KIRKLEES METROPOLITAN COUNCIL INVESTMENT & REGENERATION SERVICE

DELEGATED DECISION TO DETERMINE APPLICATIONS FOR LISTED BUILDING CONSENT

Reference No:	2025/44/91400/W
Site Address:	Oldfield Road Farm, Oldfield Road, Honley, Holmfirth, HD9 6RL
Description:	Discharge of details reserved by condition 18 (positioning of flues) on previous permission 2024/91659 for Listed Building Consent for conversion and extension of existing buildings to provide three dwellings including refurbishment of existing farmhouse and demolition of modern farm buildings with associated access and parking arrangements (Listed Building within a Conservation Area)
Recommending Officer:	Edward Cheseldine

2025/91400 – Oldfield Road Farm, Oldfield Road, Honley, Holmfirth, HD9 6RL

Drg. no.	Rev.
253-24-PL01	B

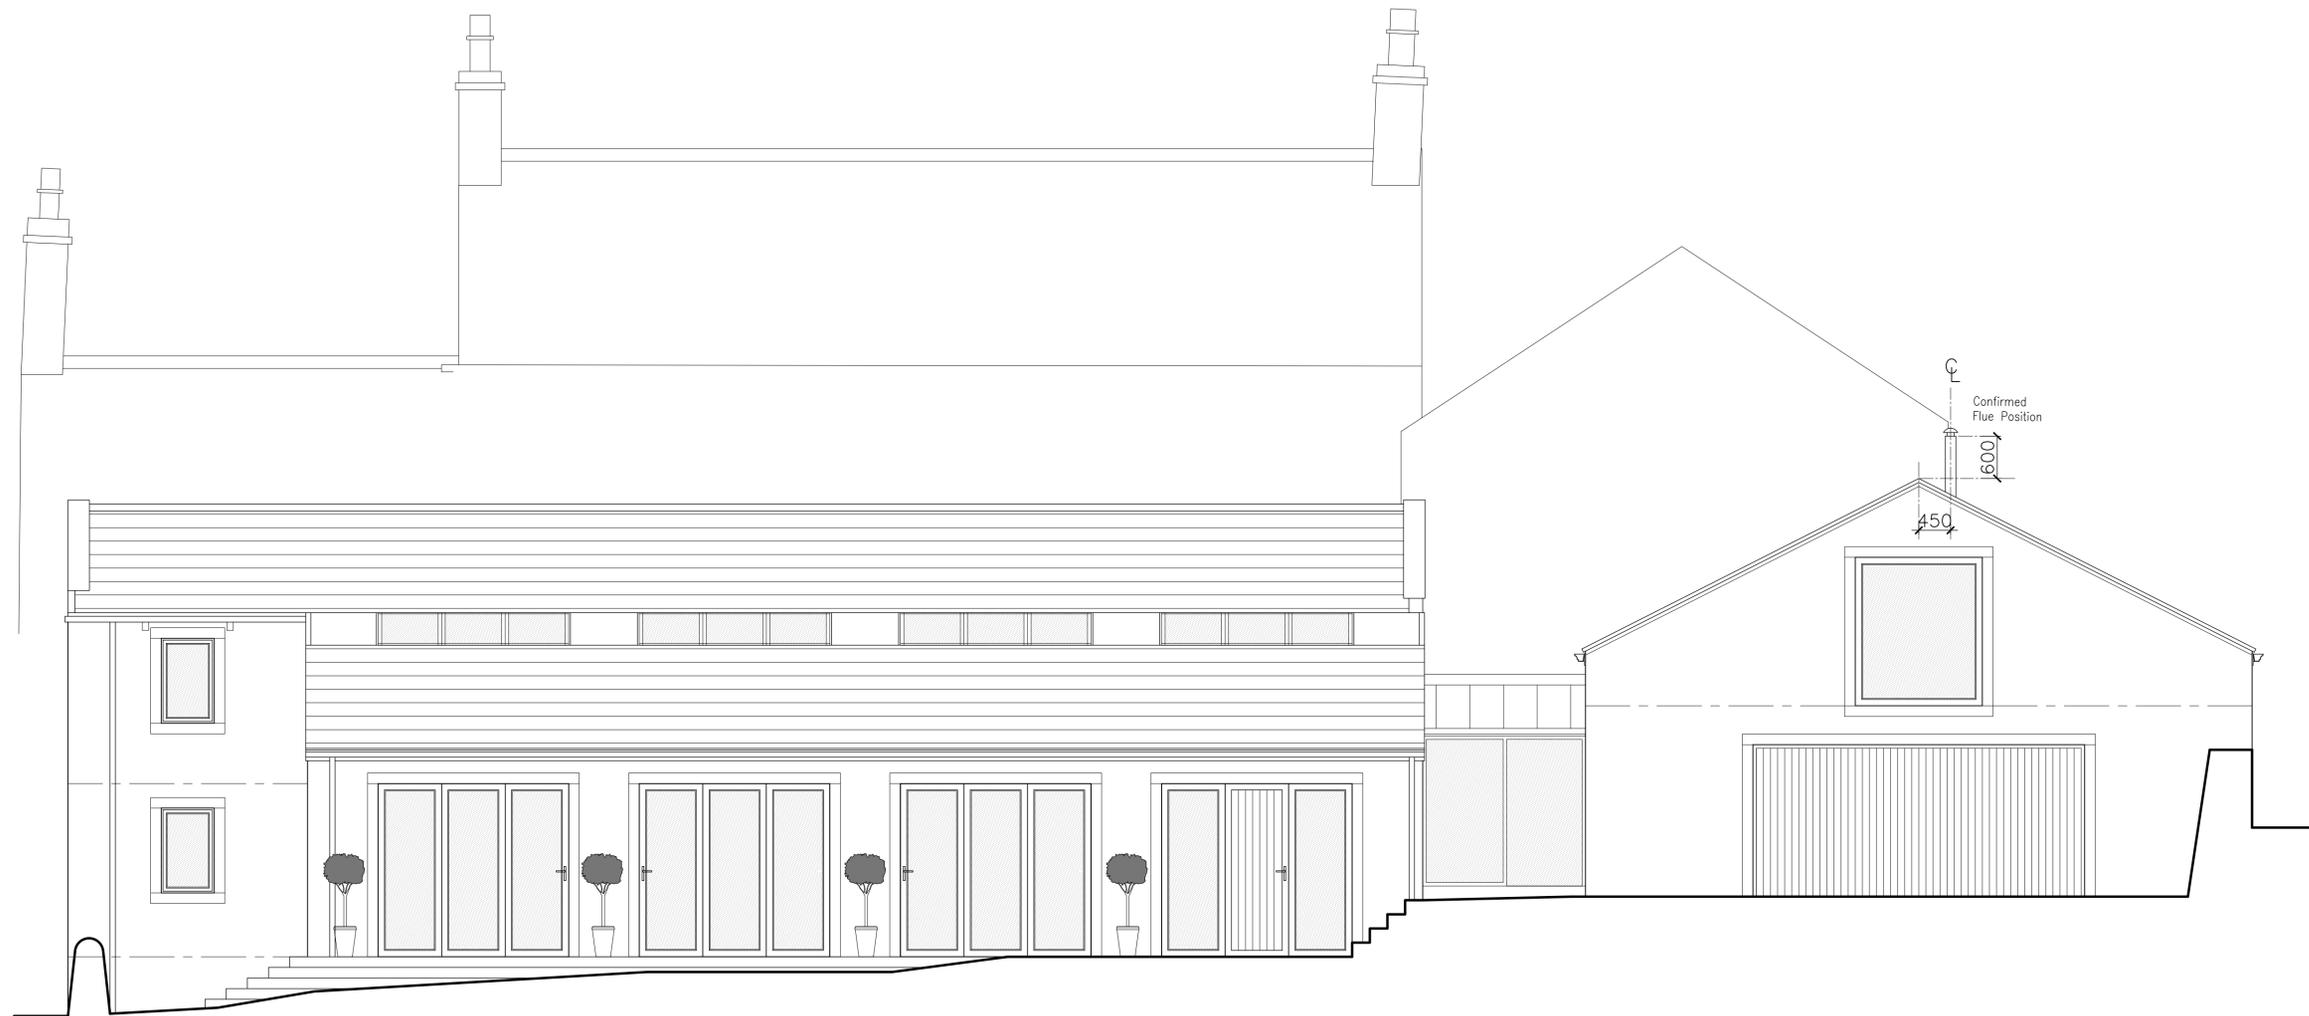
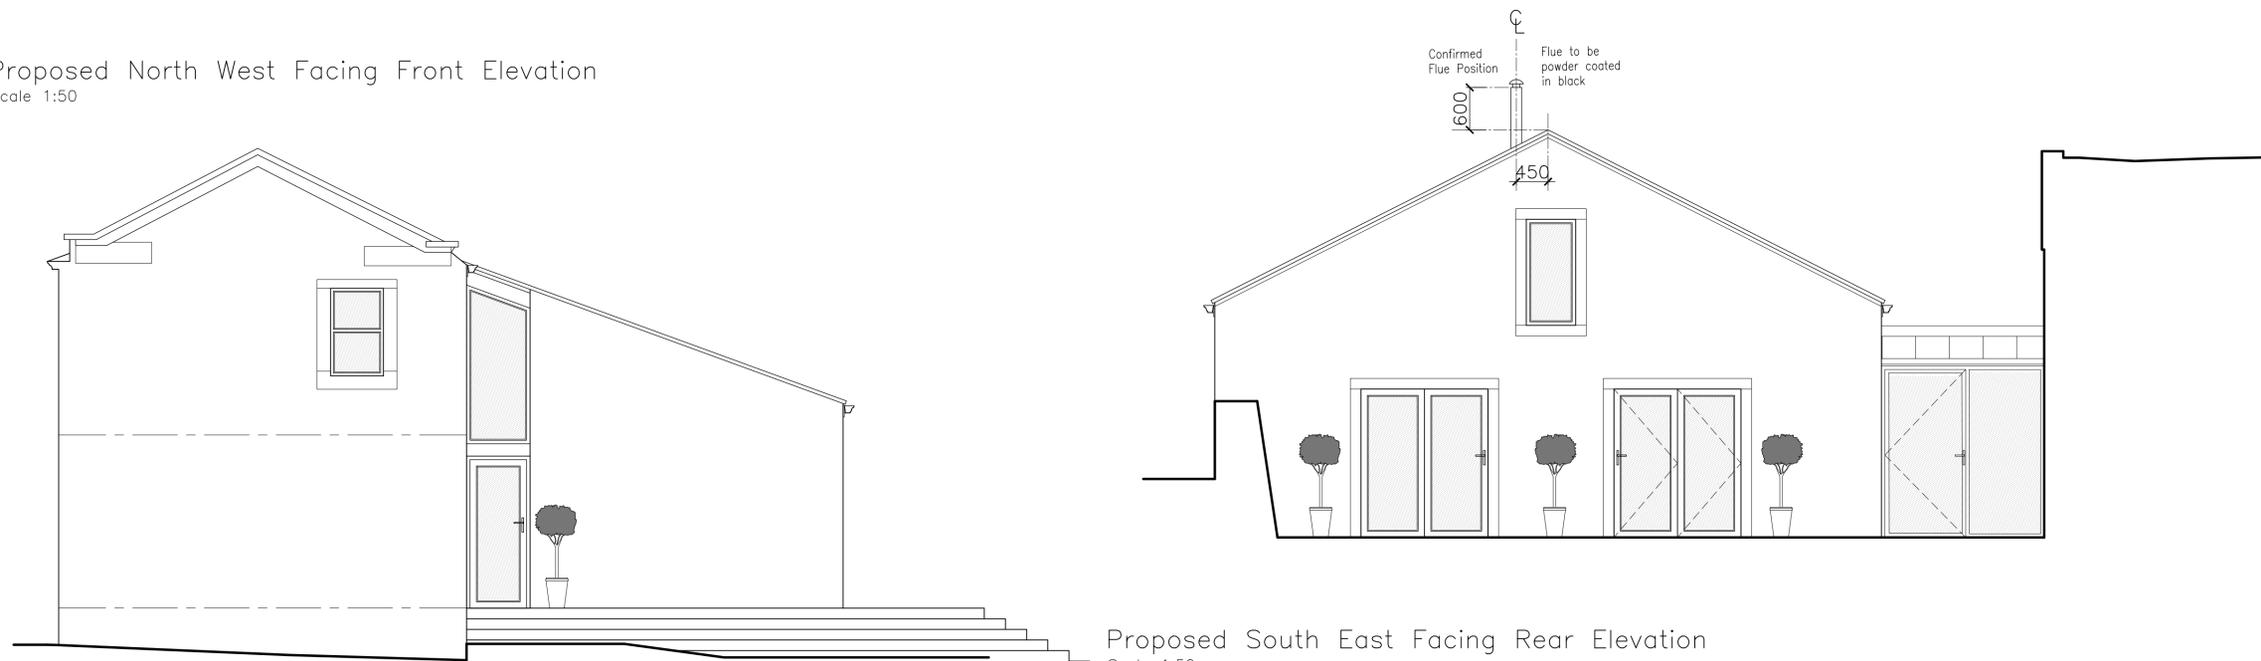
For the purposes of the assessment, KC Conservation & Design were consulted regarding the proposed location and design of the chimney flue. They raised no objection to the placement of the proposed chimney flues, due to their size and scale which maintains the agricultural appearance of the buildings. The chimney flues are minimal, with the fixing into roof slates being fully reversible.

It was requested that the chimneys are powder coated in a black colour blending into the building. Amended plans were submitted to identify the flues will be finished in a black colour.

Based on the consultation with KC Conservation & Design, and due to the submission of amended plans identifying the flues as black, the condition can be discharged so long as the installation of the flues accords with the submitted plans and retained thereafter.
